Direct Line: 01622 653234
E-mail: pandcr@kent.police.uk
Date: 27th July 2020
Ref: SE-178/19/05000/HYB/AF2

Application Ref: SE/19/05000/HYB
Location: DSTL Fort Halstead Crow Drive Halstead
Proposal: Hybrid application comprising, in outline: development of business space (use classes B1a/b/c) of up to 27,773 sqm GEA; works within the X enclave relating to energetic testing operations, including fencing, access, car parking; development of up to 635 residential dwellings; development of a mixed use village centre (use classes A1/A3/A4/A5/B1a/D1/D2); land safeguarded for a primary school; change of use of Fort Area and bunkers to Historic Interpretation Centre (use class D1) with workshop space and; associated landscaping, works and infrastructure. In detail: demolition of existing buildings; change of use and works including extension and associated alterations to buildings Q13 and Q14 including landscaping and public realm, and primary and secondary accesses to the site.

Amended Consultation

Illustrative view of feature corner (2) of Block B adjacent to the Penney (Q14)

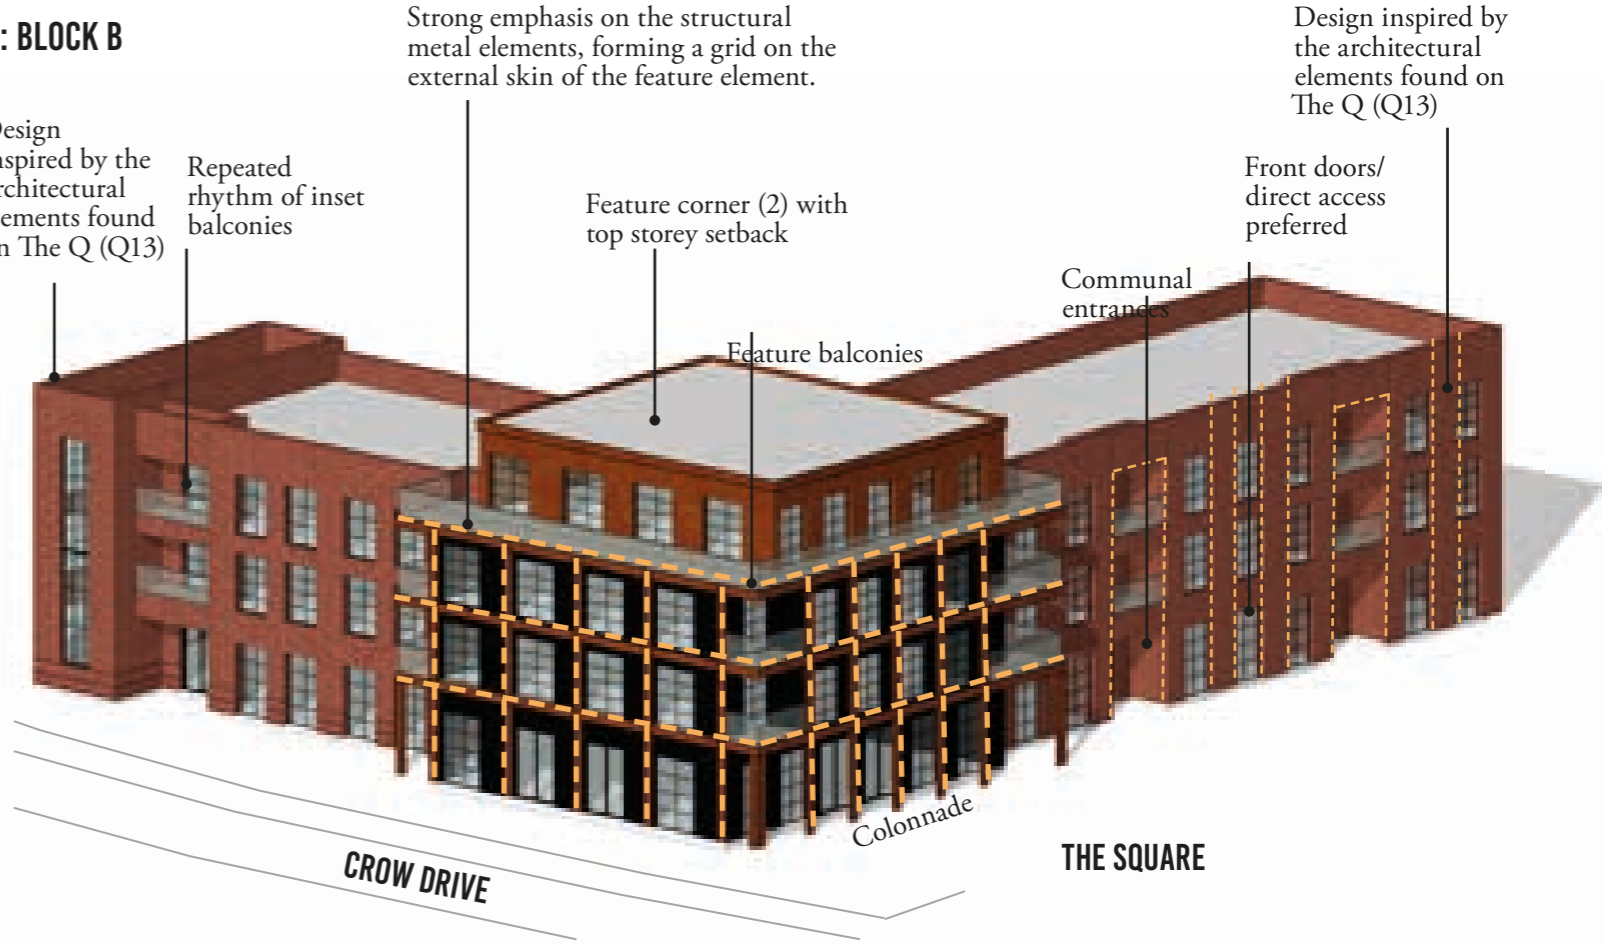
6. Corner Properties and defensible spaces.
7. Recesses. We note the inclusion of recesses as part of the building design of the proposed Blocks (e.g. Block B). These recesses give us some cause for concern as they may provide hiding areas and opportunities to commit crime.
